**From:** Claire Booth  
**Sent:** 09 July 2012 16:01  
**To:** Jane Tucker  
**Subject:** FW: Planning application consultation - 3/2012/0485 97 Hacking Drive, Longridge  
Highway comments

**From:** Hornby, Mark [mailto:Mark.Hornby@lancashire.gov.uk]  
**Sent:** 09 July 2012 15:57  
**To:** Claire Booth  
**Cc:** ENV EPP Customer Service Area East  
**Subject:** Planning application consultation - 3/2012/0485 97 Hacking Drive, Longridge

SITE PLAN scale 1:500

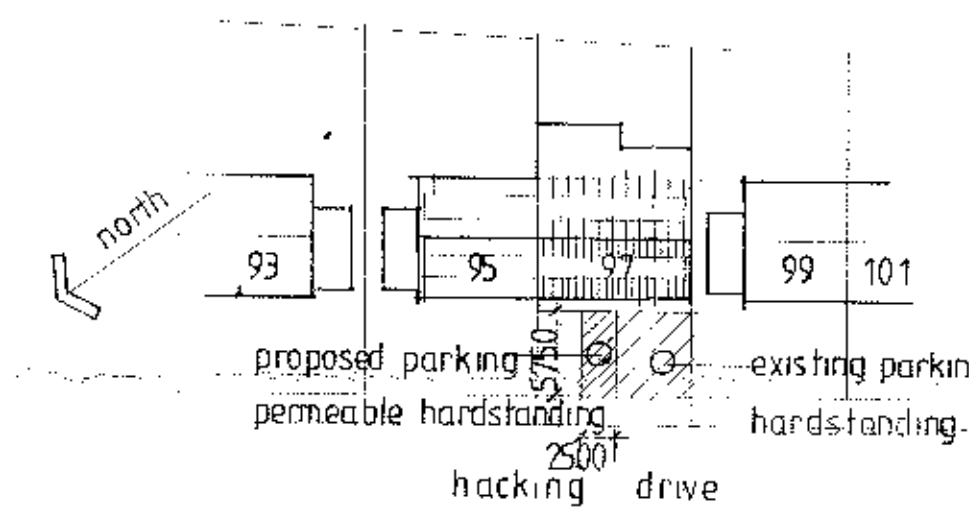
I have no objection to this proposal, however the additional parking space proposed will require an extension to the existing dropped kerb to allow vehicles to enter and leave the highway safely (as in fact does one of the existing two parking spaces). Please add the following note to any consent granted:

Note: This consent requires the construction, improvement or alteration of an access to the public highway. Under the Highways Act 1980 Section 184 the County Council as Highway Authority must specify the works to be carried out. Only the Highway Authority or a contractor approved by the Highway Authority can carry out these works and therefore before any access works can start you must contact the Environment Directorate for further information, details below:
